Description: Change of use from private dwelling to 3 self-contained apartments. Two storey side extension and rear extensions. New dropped kerb to side/rear, new parking area and solar panels to roof.

Site Address: 2 Houghton Road, Thurnscoe, Rotherham, S63 0JT

This application seeks permission for a change of use from a private dwelling to 3 self-contained apartments, a two-storey side extension and rear extensions. In addition to a new dropped kerb to side/rear, new parking area and solar panels to roof.

PROPOSED GROUND FLOOR PLAN.

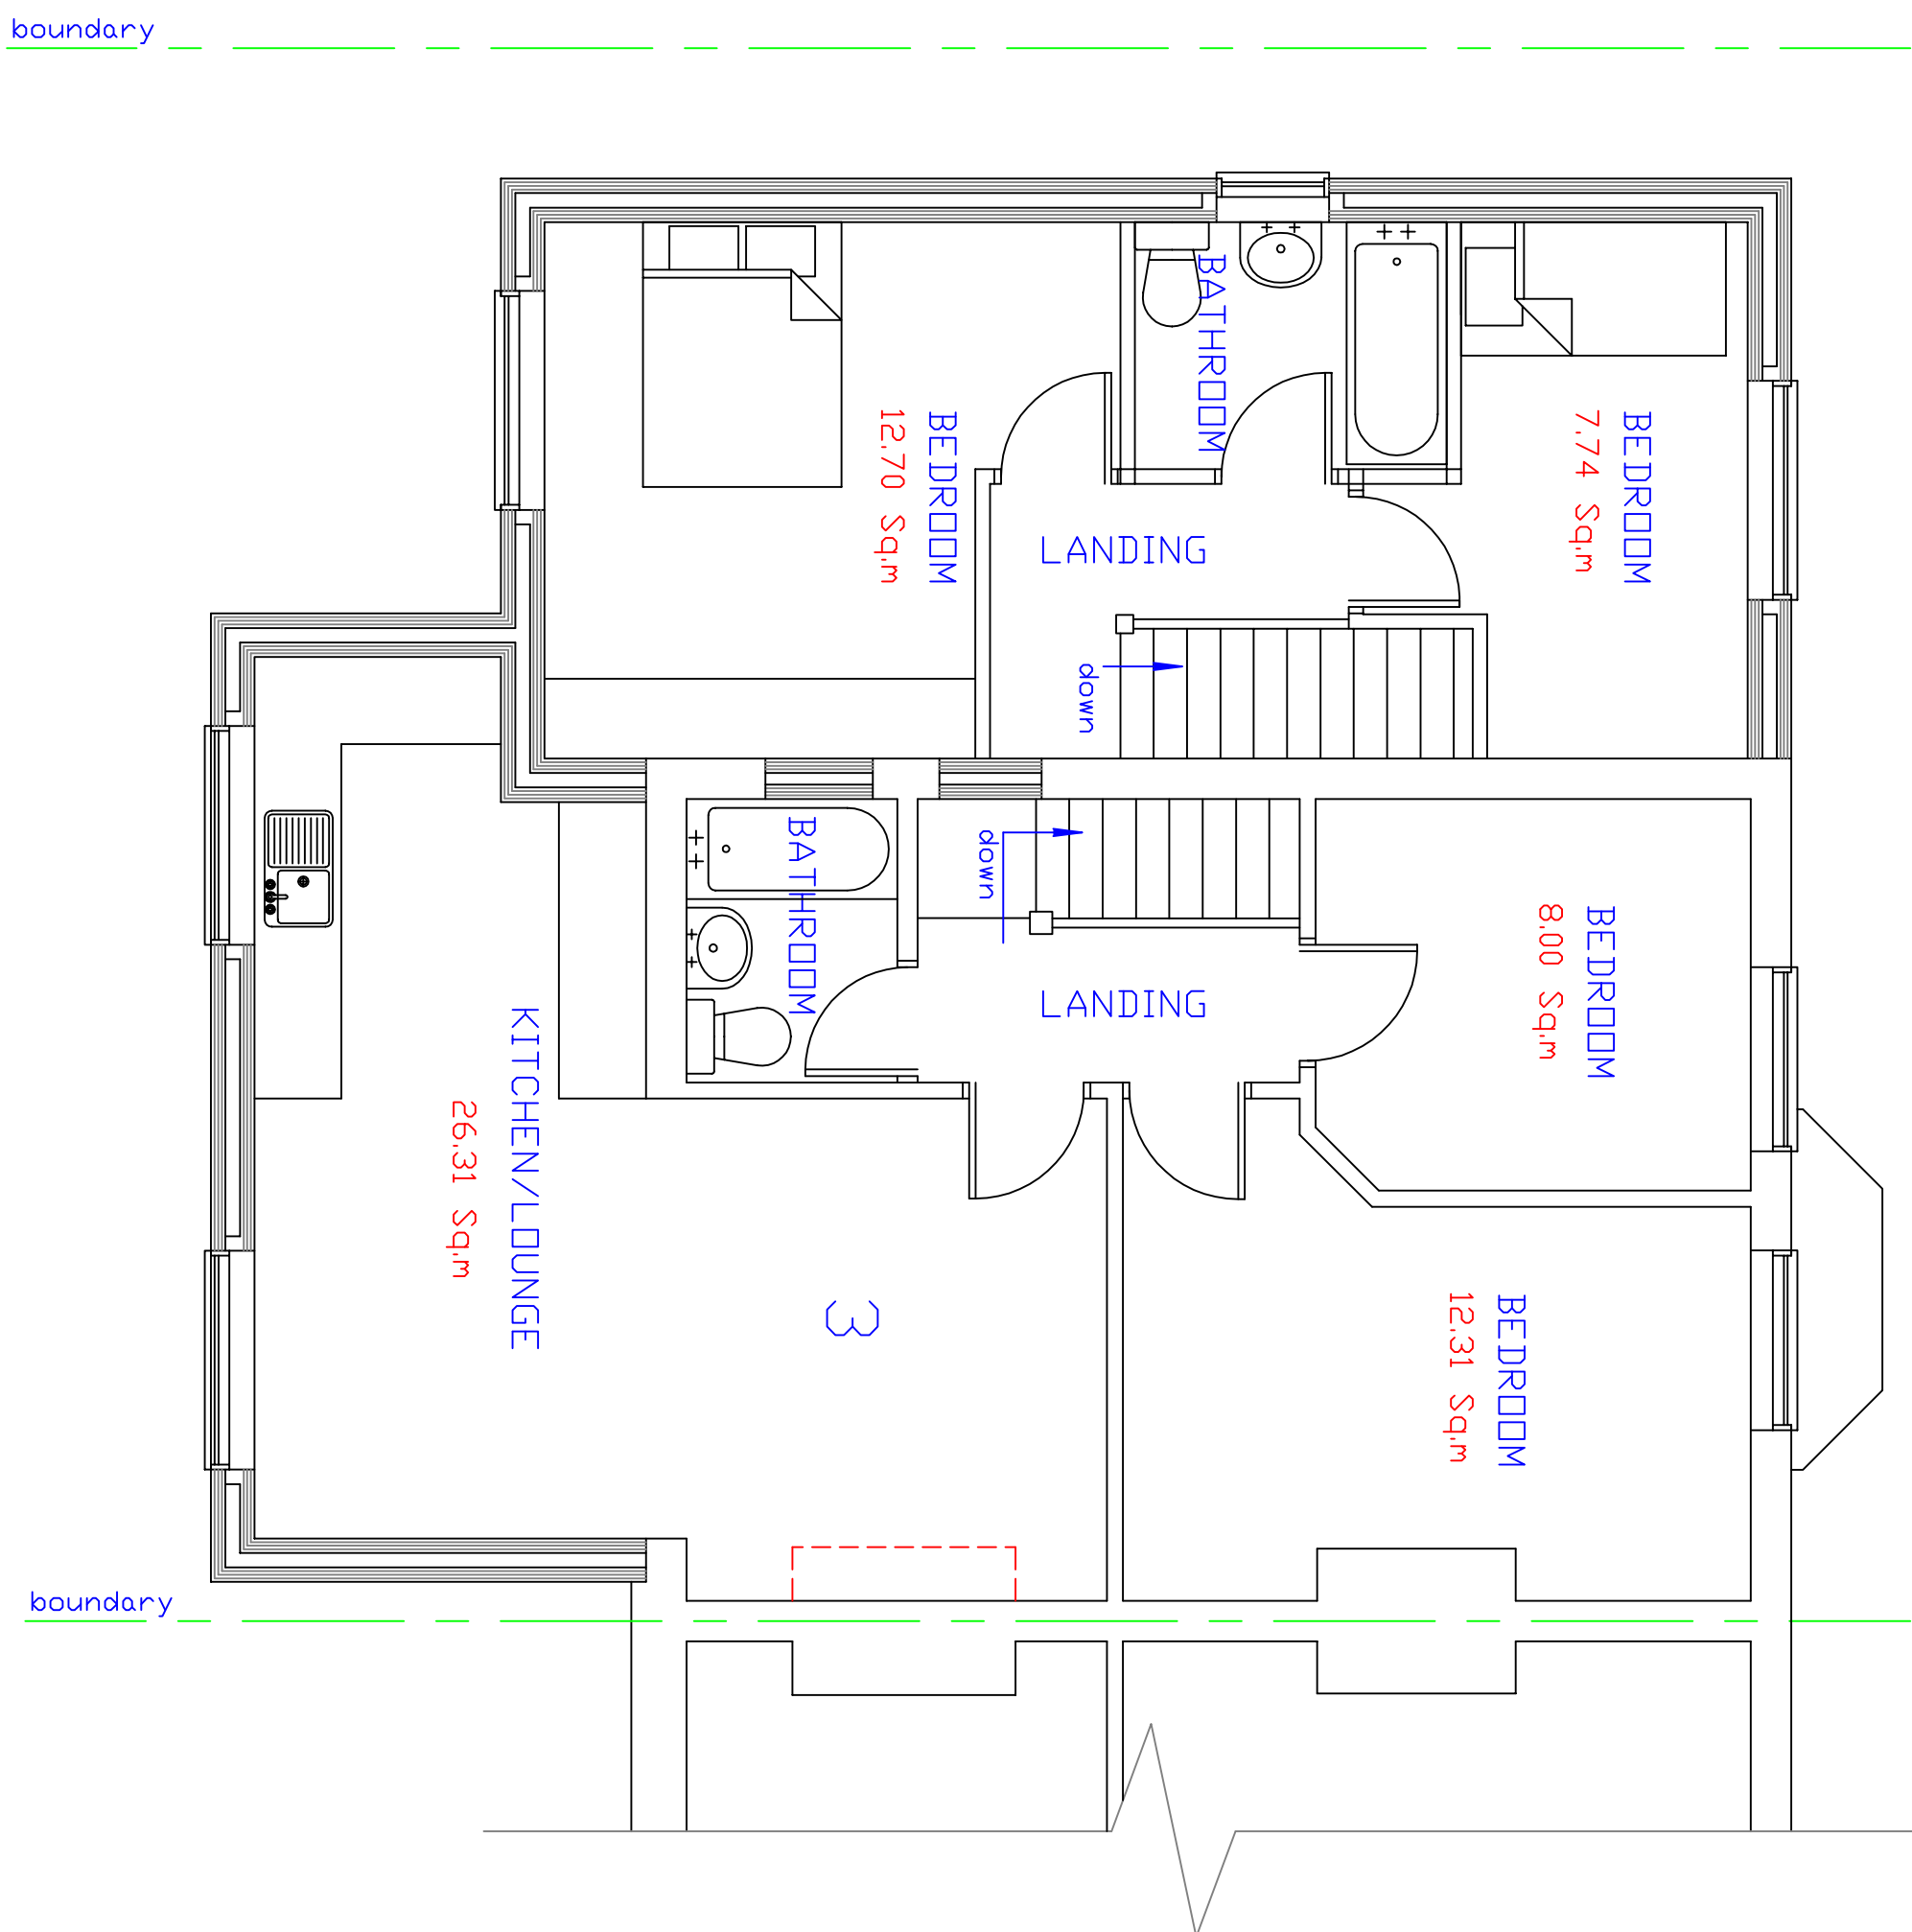
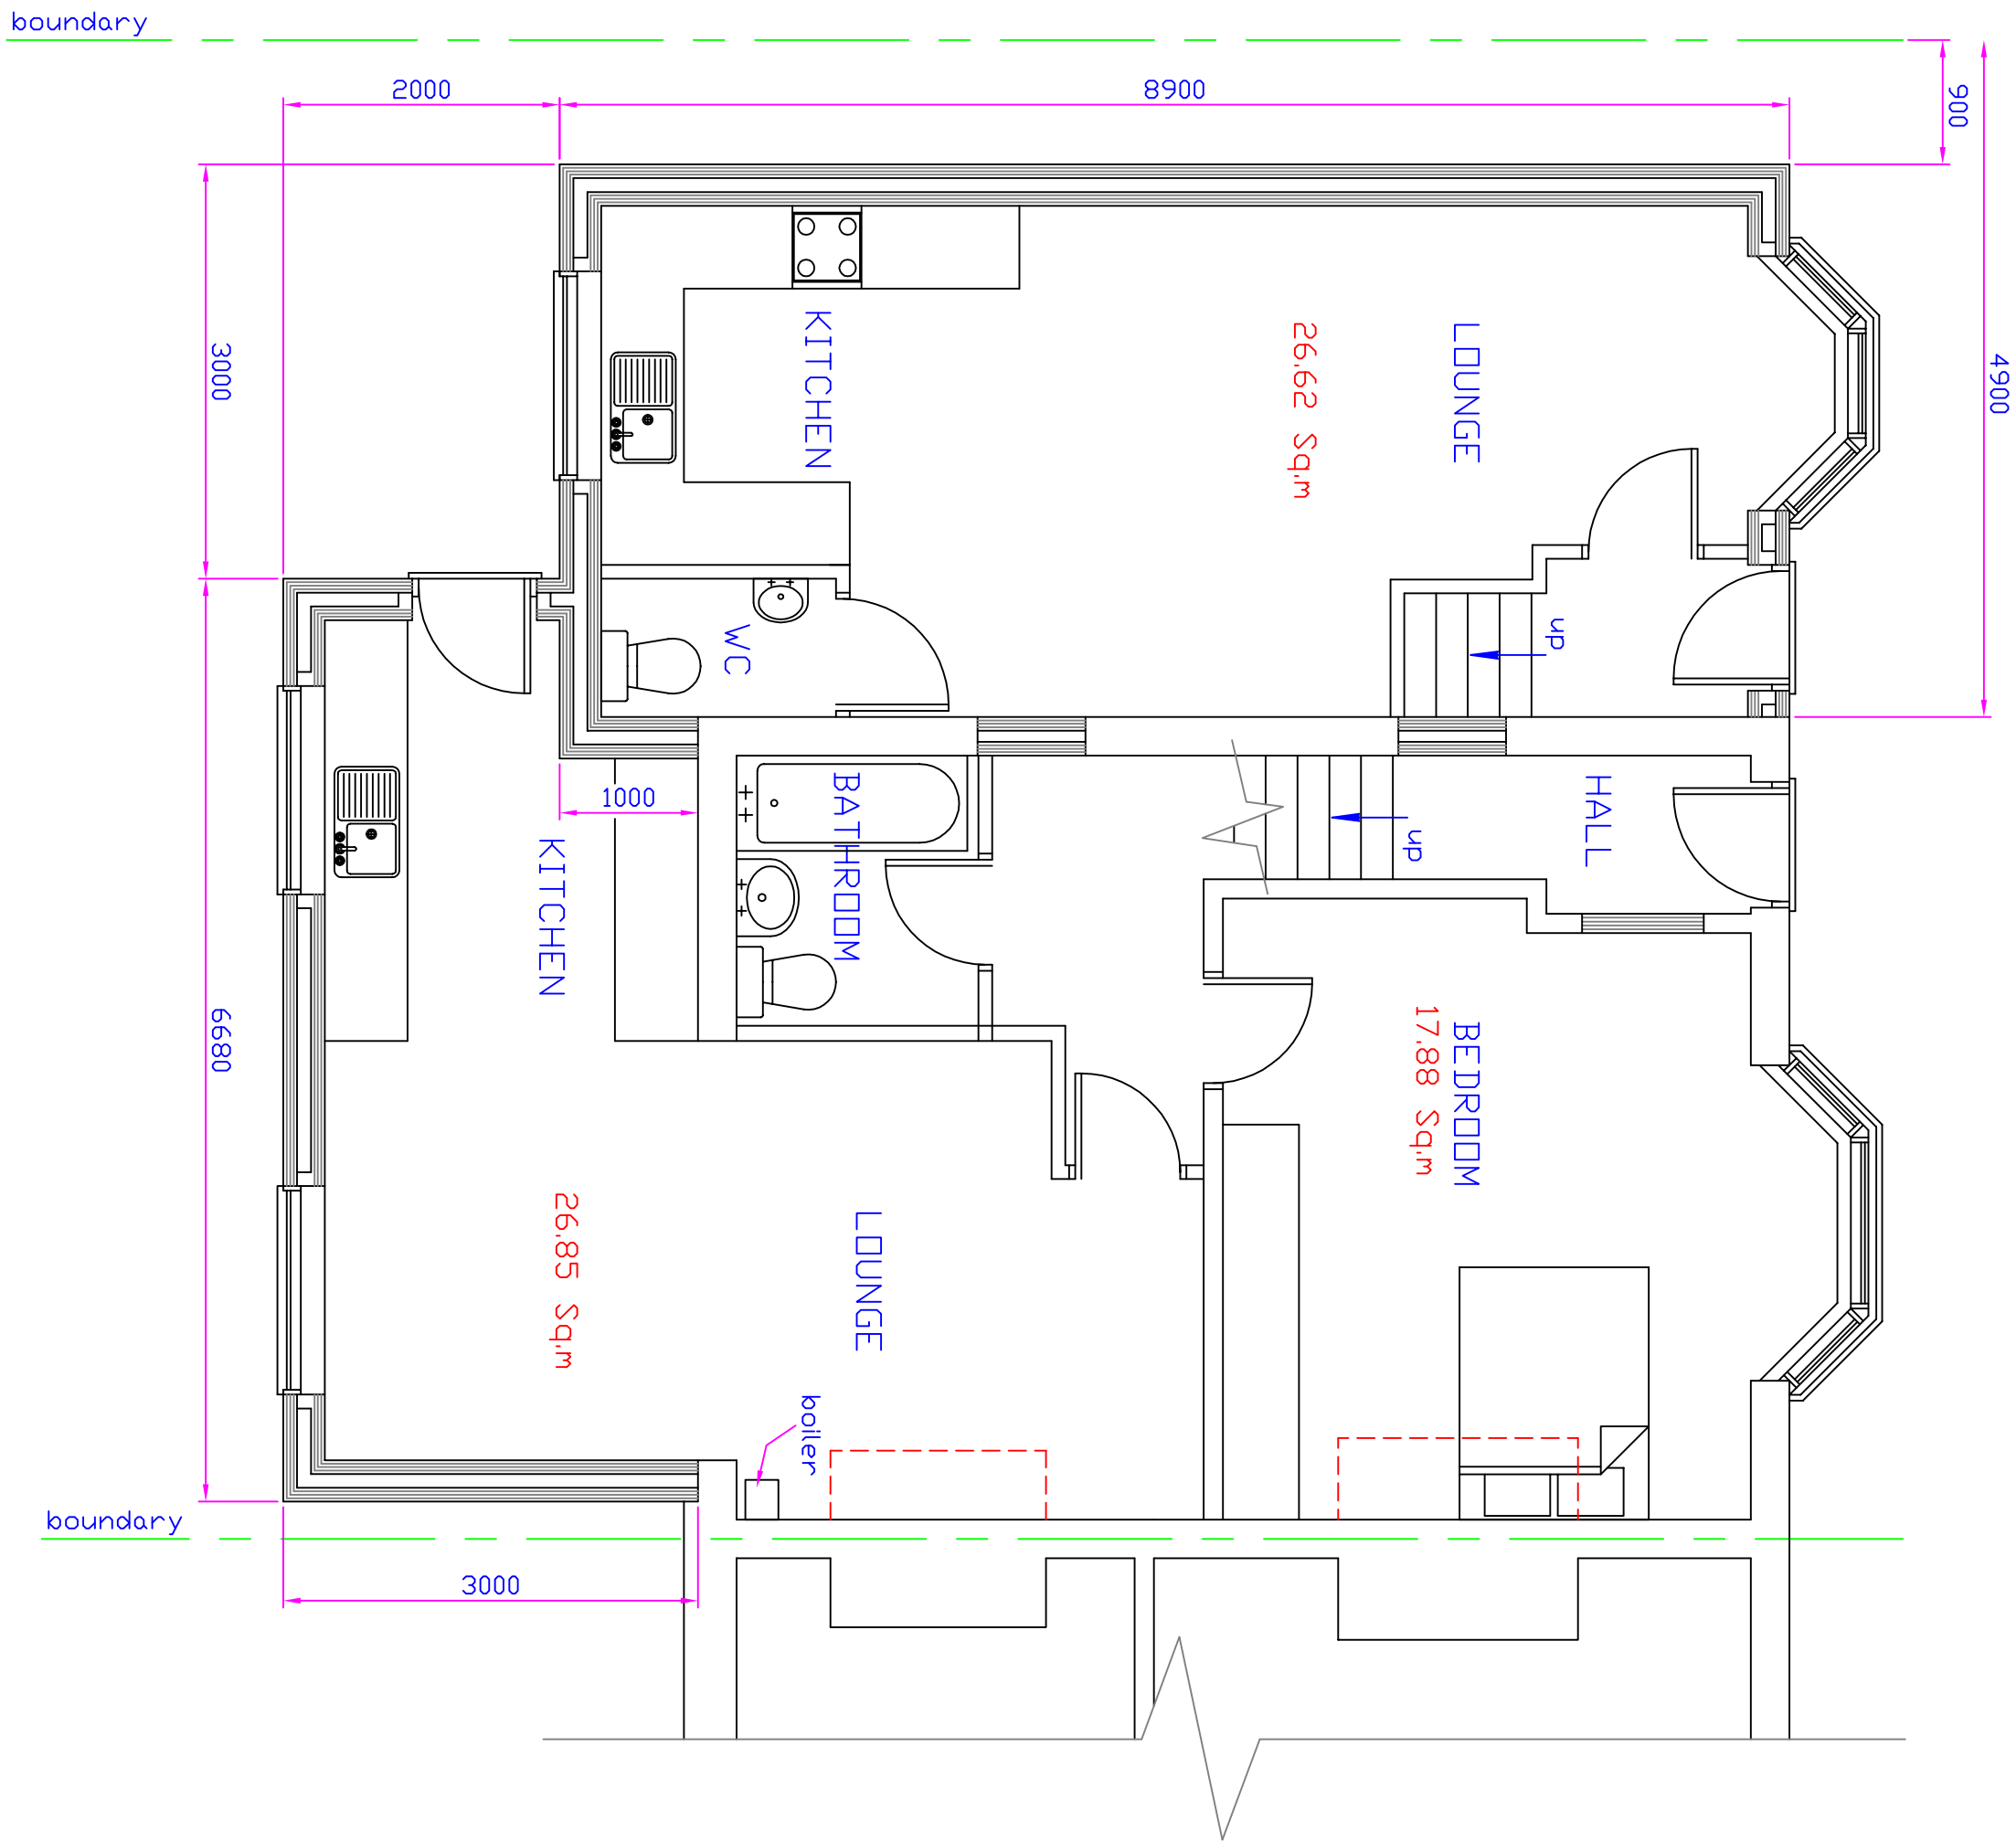
The proposed apartments comprise 1- and 2-bedroom apartments. All habitable rooms would be served by windows to allow for sufficient light and outlook. In terms of internal amenity, the bedrooms have been shown on the proposed plans as a mixture of double and single bedrooms. The South Yorkshire Residential Design Guide states that the minimum GIA should be 7sqm for a single bedroom, 12sqm for a double bedroom and at least 2m in width. All bedrooms would meet the minimum standards. Whilst two of the apartments meet the overall space standards for a 1 and 2 bed apartment, the 2-bed apartment at first floor labelled as apartment 3 would be undersized at approximately 51.66sqm with a slightly undersized kitchen/lounge. The apartment should be 62sqm and is therefore inadequate.

Overall, the living conditions would be inadequate due to the shortfall in overall internal amenity space for flat 3 of the development and this would be detrimental to future residents, contrary to Local Plan Policy GD1.
